From: Bruce Taunton [REDACTED]
Sent: 04 February 2022 09:50
To: Planning.Responses <Planning.Responses@arun.gov.uk>
Subject: RE: Planning Consultation on: A/10/22/PL

Application No: A/10/22/PL
Registered: 28th January 2022
Site Address: The Decoy Decoy Lane Angmering BN18 9QA
Grid Reference: 505841 105353
Description of Works: Part demolition and rebuild, and part conversion of existing stable and barn buildings to 1 No. habitable dwellinghouse. This application may affect the setting of a Listed Building. This application is in CIL Zone 3 and is CIL liable as new dwelling (Resubmission of previously approved A/17/18/PL).

Fig 2a – Shoring Positions

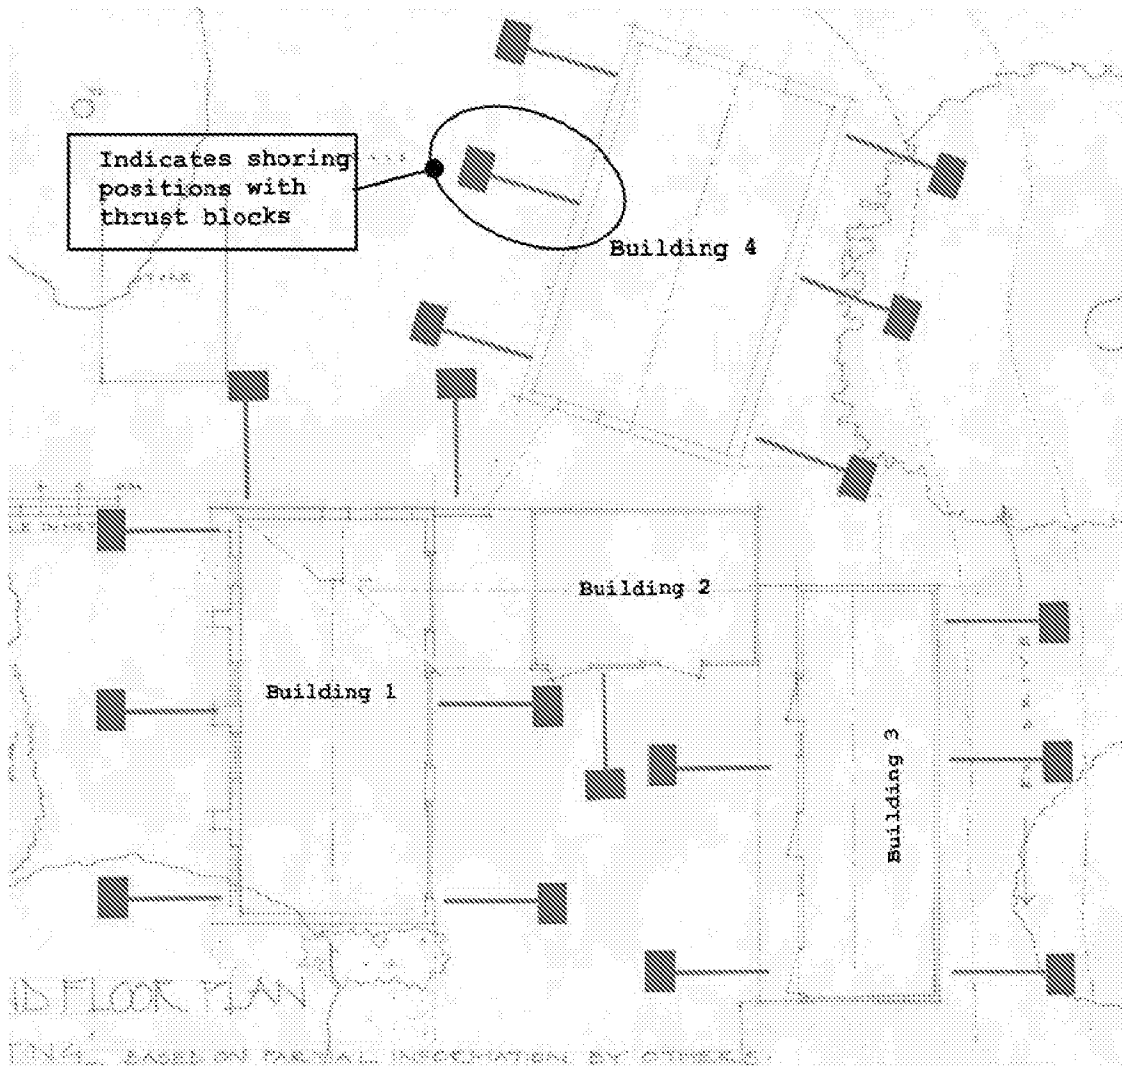
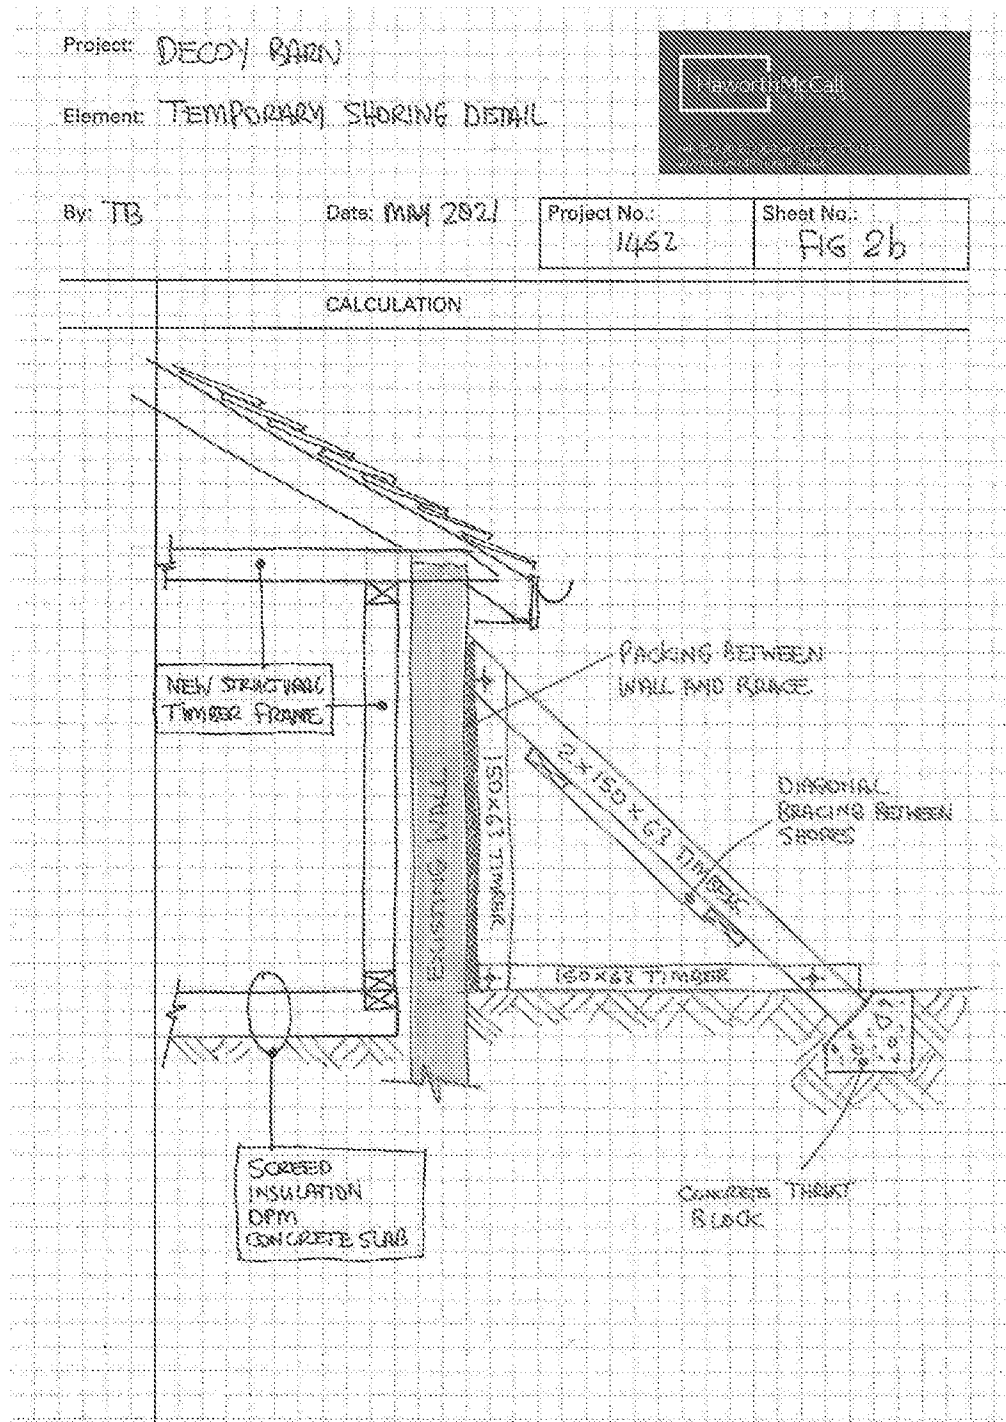
The proposed construction method statement and proposed propping is considered acceptable.
